Landowner Position Statement – Field

- 1.1.1 National Highways have prepared a series of Position Statements with landowners) directly impacted by the A417 Missing Link project. These have been prepared in collaboration with the District Valuer Services (DVS), National Highways Property and Compensation Team and National Highways Project Management Team to inform ongoing discussions about land interests.

Drawing Title: **FIGURE 13.19 SCHEME HIGHWAY DRAINAGE - PLAN**

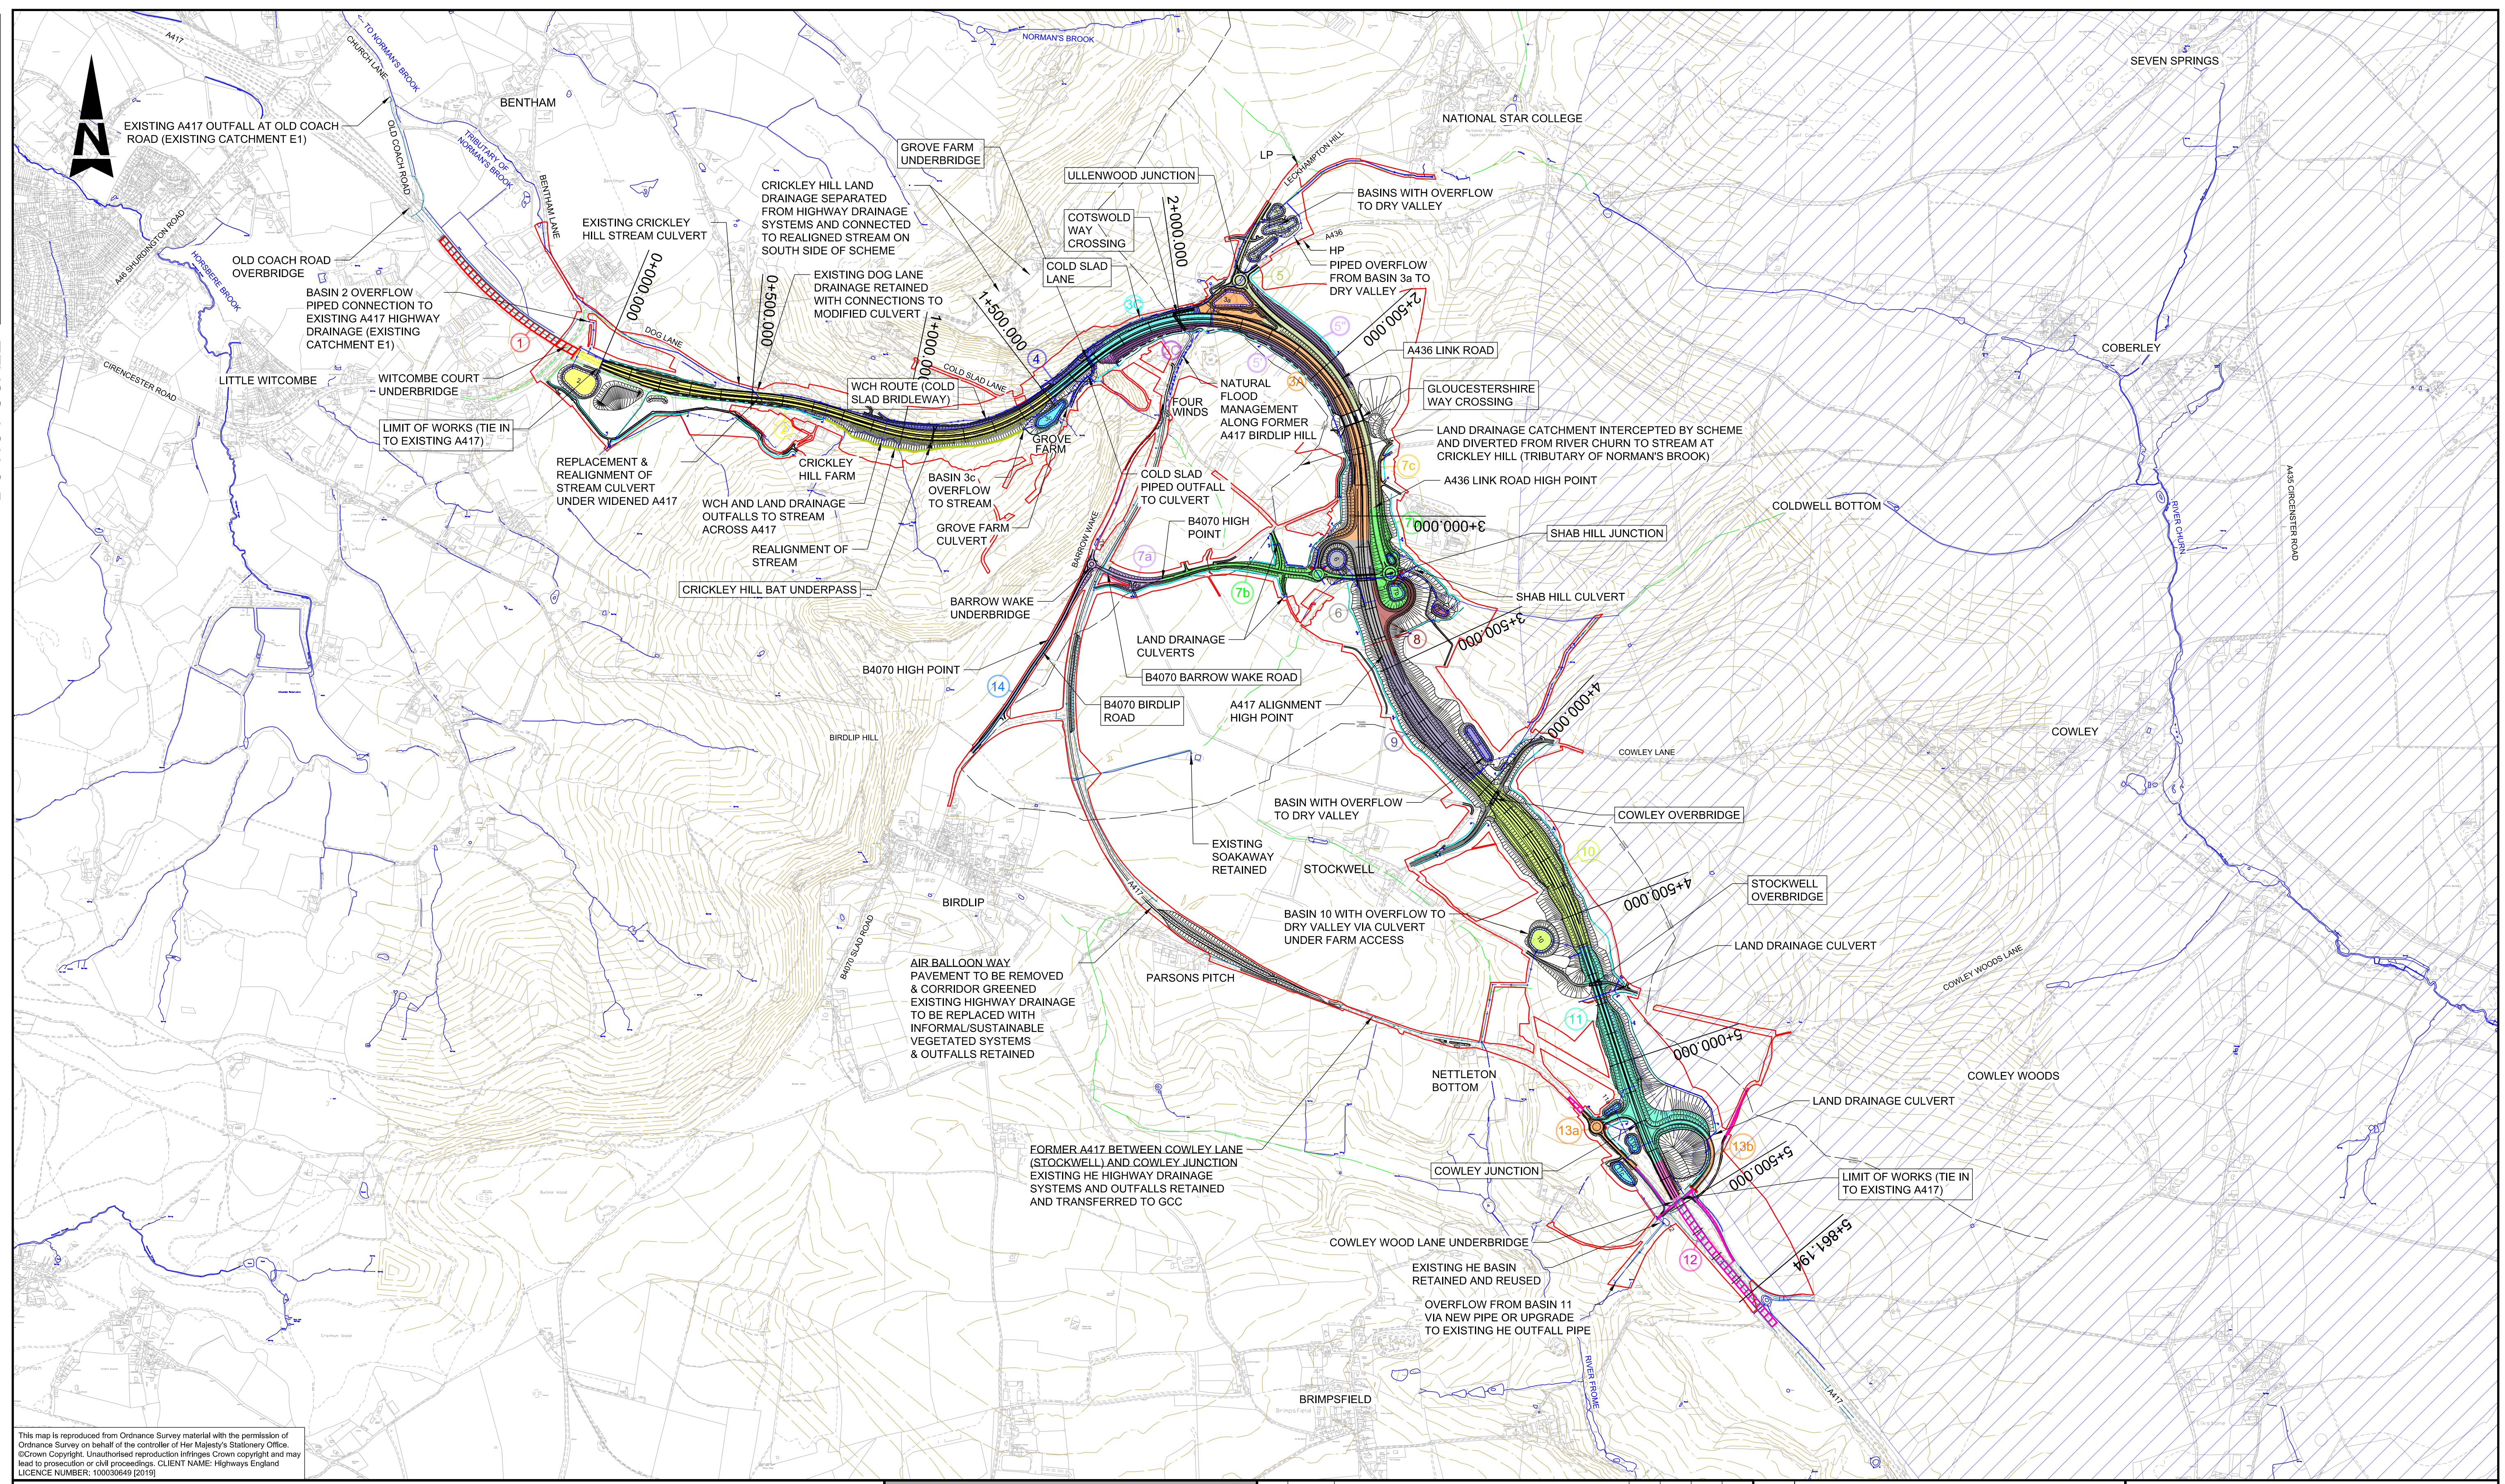
3	Drainage	The Field's raised concerns about the drainage pipe going through their land for the purposes of the scheme. The Field's questioned why the pipeline could not run along the whole of the south side of their property on National Highways land and only enter their property after the last manhole on National Highways side of the boundary.	The route of the drainage pipe has been revised to take the minimum amount of land and also lie as far to the west of the Field's land holding as possible. The last pipework plan I have is dated 29.01.21. Has pipework been revised since and if so please could you supply me with a copy of the updated plans
4	West Boundary Land	The Field's raised concerns about their western boundary land that they state was wrongly taken by National Highways for the scheme back in the early 90's. The Field's request that this matter is resolved before the end of the scheme's construction. The Field's stated that the trees should be cut down and left at the property and all roots removed by National Highways.	The previous scheme created an incorrect land ownership boundary. As such during the preliminary works for the A417 missing link scheme, the fence line will be moved and appropriate vegetation clearance undertaken to provide the land back to the Field's and show the correct land ownership boundary. I seek clarification that your wording 'appropriate' means full clearance back to a grazing field as prior to the wrongful take.
